REQUEST

Proposed Zoning: I-2(CD) (general industrial, conditional)
Approximately 63.22 acres located on the north and south side of Morris Estate Drive, east of North Graham Street, and west of IBM Drive.

STAFF RECOMMENDATION

Staff recommends approval of this petition upon resolution of outstanding issues related to Environment.

RZ-1

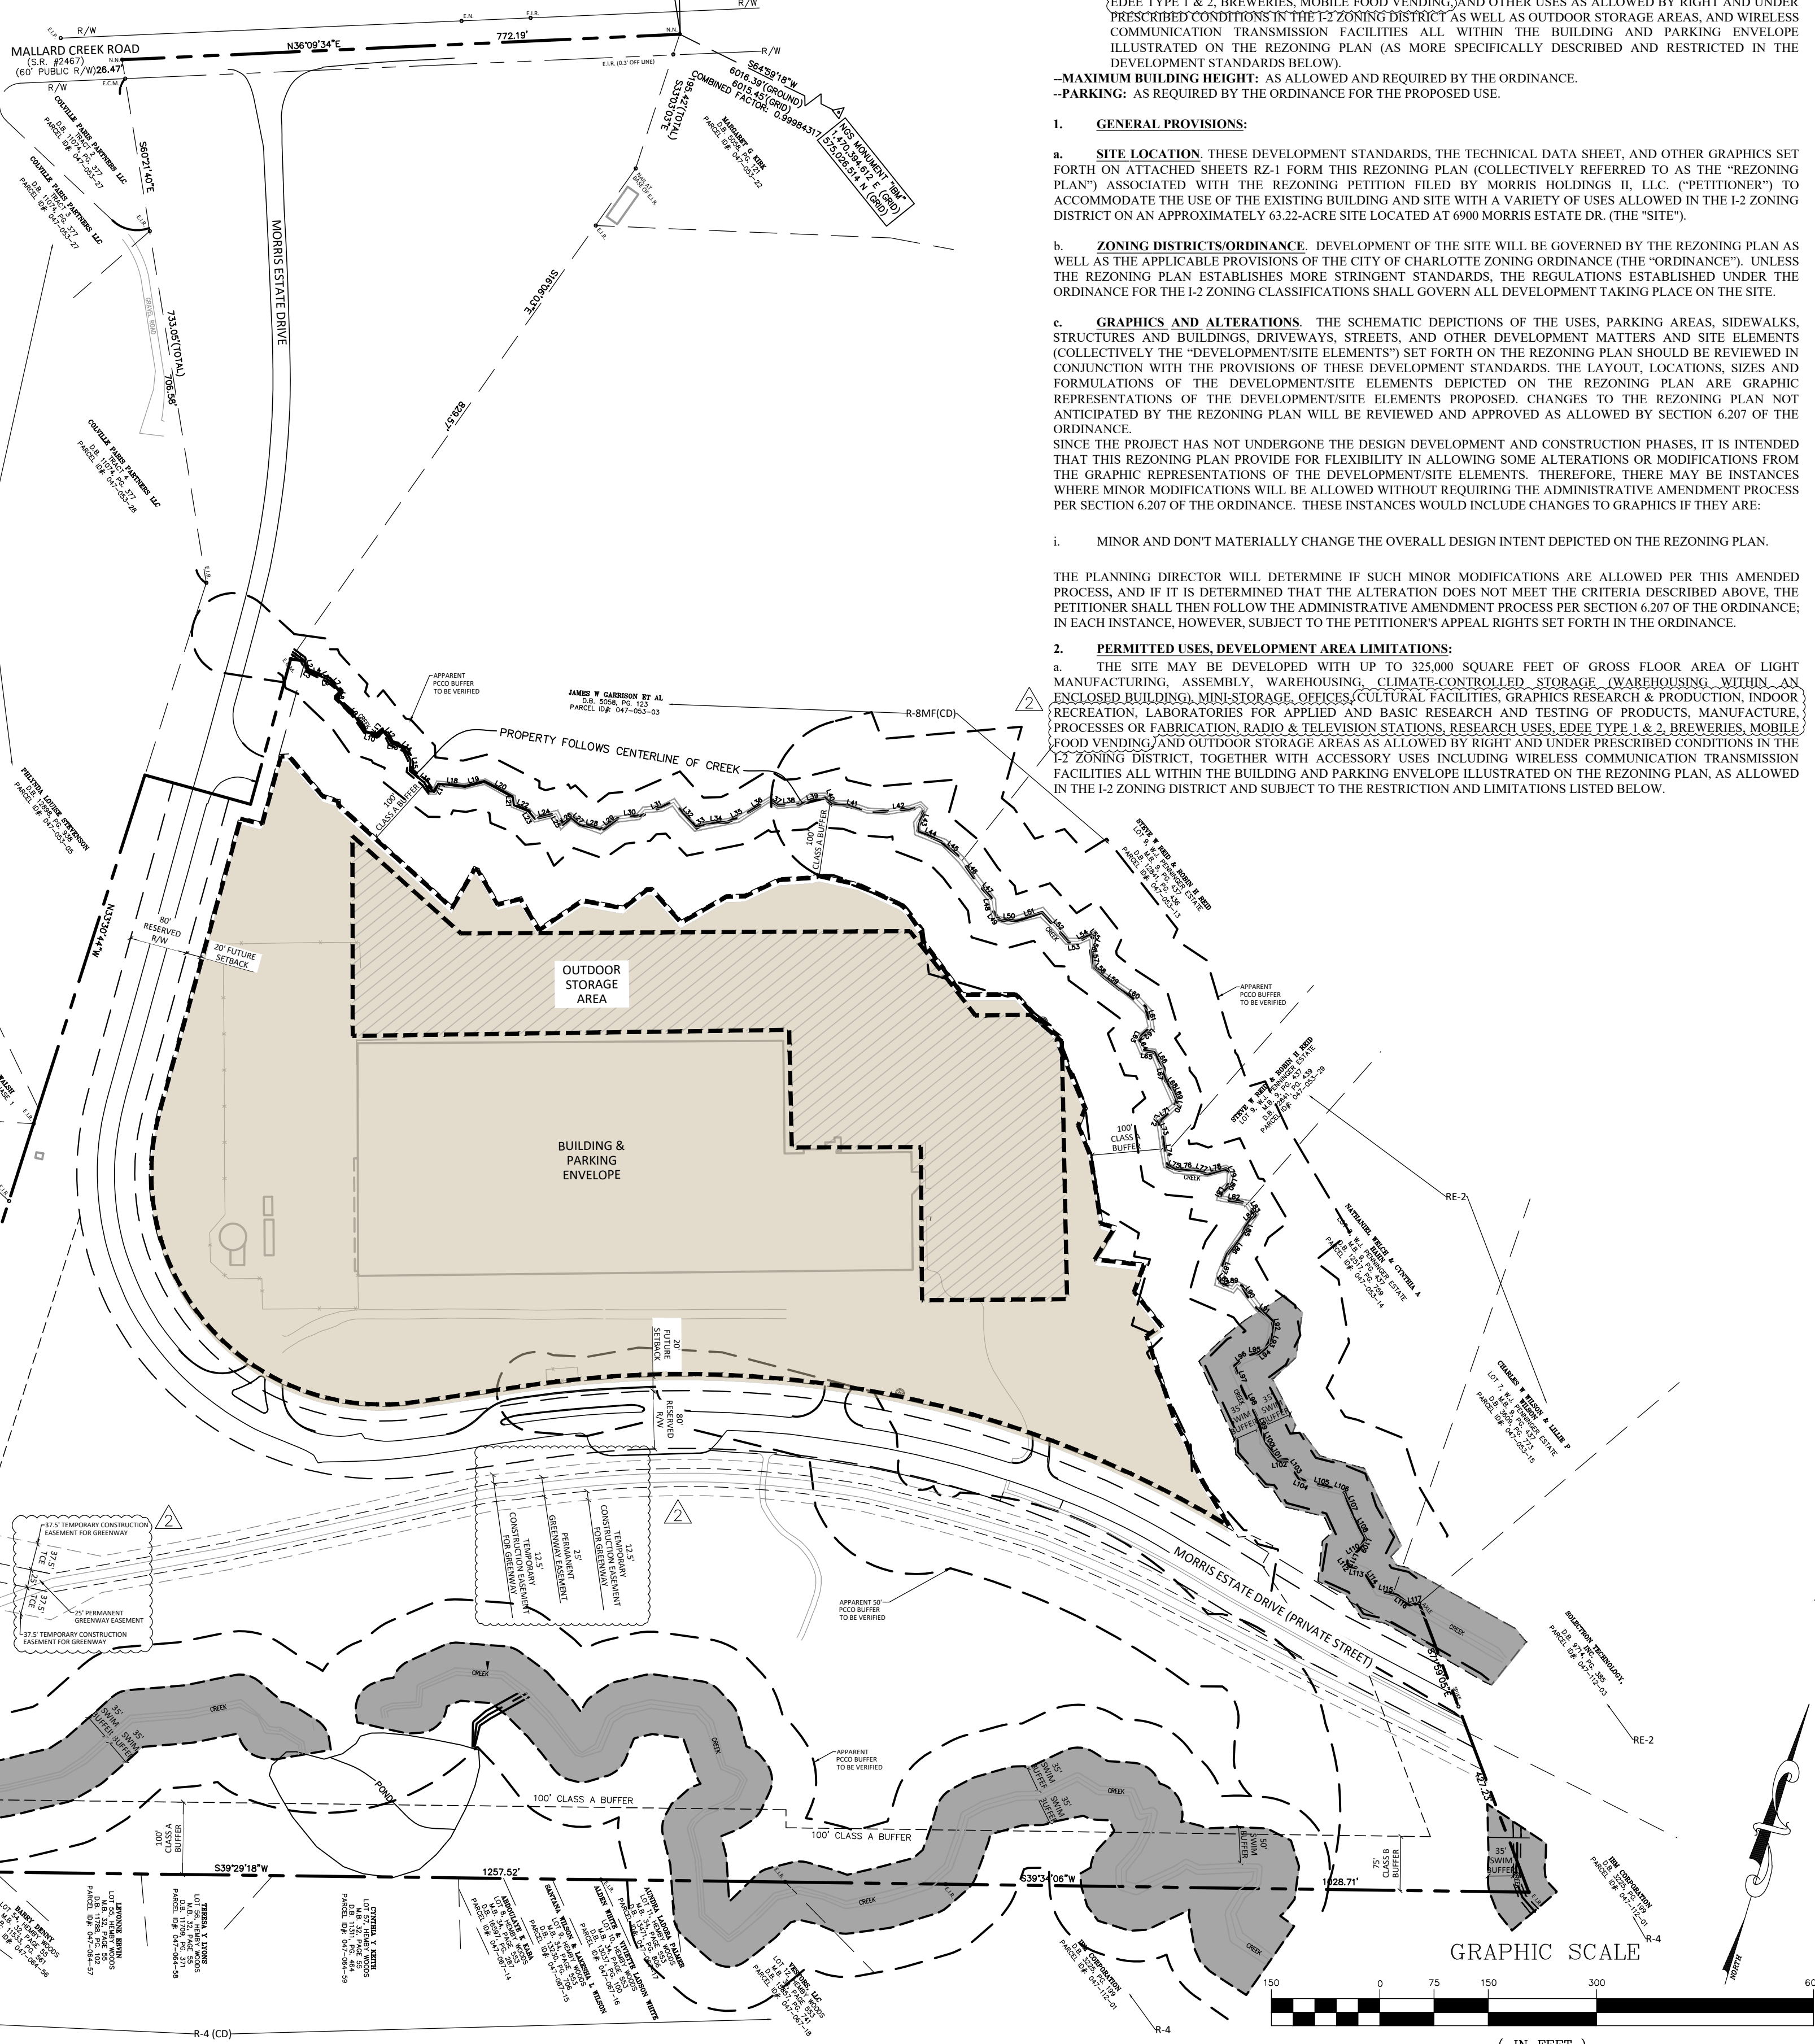
1. The previous submitted site plan identified the 100' greenway easement area adjacent to Morris Estate Drive. MCPR requests that the proposed easement be consistent with this initial proposed area, with the addition of the connection to Nevin Road.
